Heritage Advice

Building 119 FFMT shed at Bicester Heritage - Reference 18/00745/F

Garry Campion, Senior Conservation Officer

4.6.2018

Building 119 - Parapet Detail - Proposed Cladding

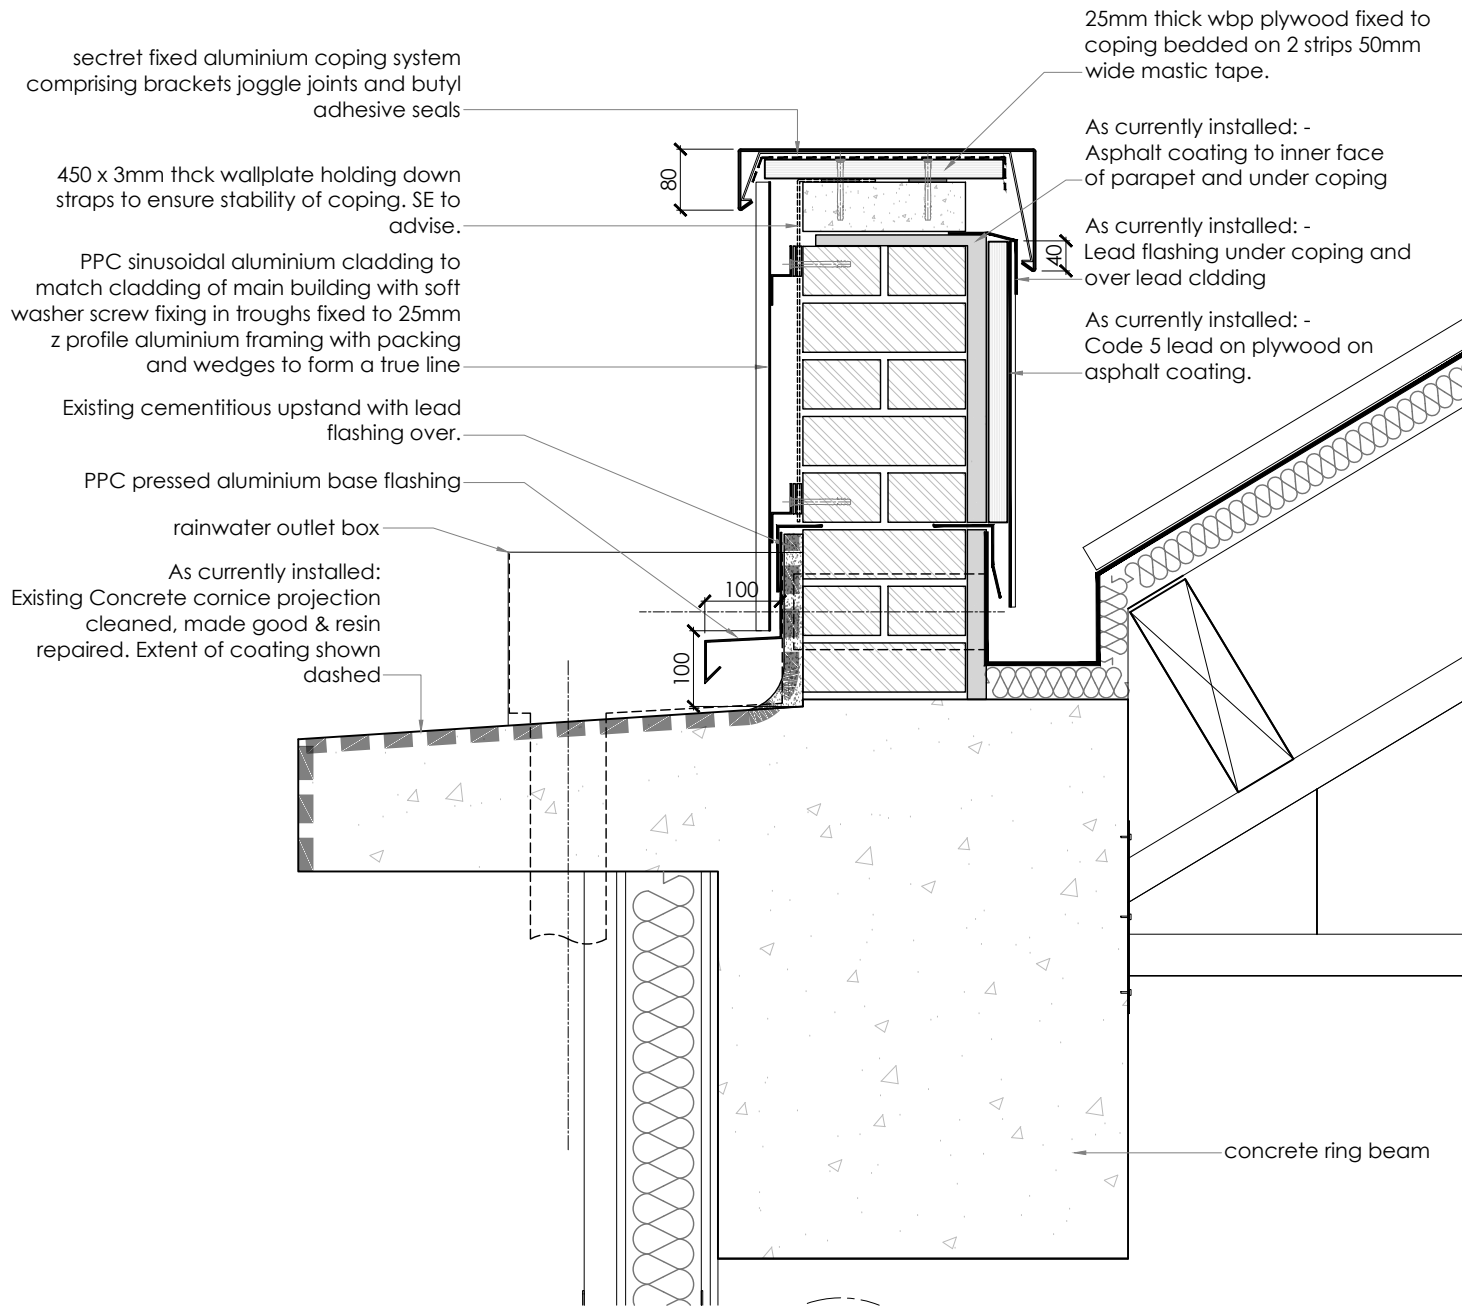
Given that the building has been significantly altered and remodelled for modern use within the site, the rebuilding of the parapetting was considered on balance to pose practical difficulties – both practically, but also in terms of bringing the building into use. Given the works to Building 119 to this point, the character of the Conservation Area is not unduly affected by the proposed solution, and it also retains the earlier parapetting, whilst cladding this in a material in keeping with the remainder of the building.

The proposed solution is supported in heritage terms as the best option given the building's remodelled appearance, the limited impact upon the character of the Conservation Area, and the need to bring the building into use.
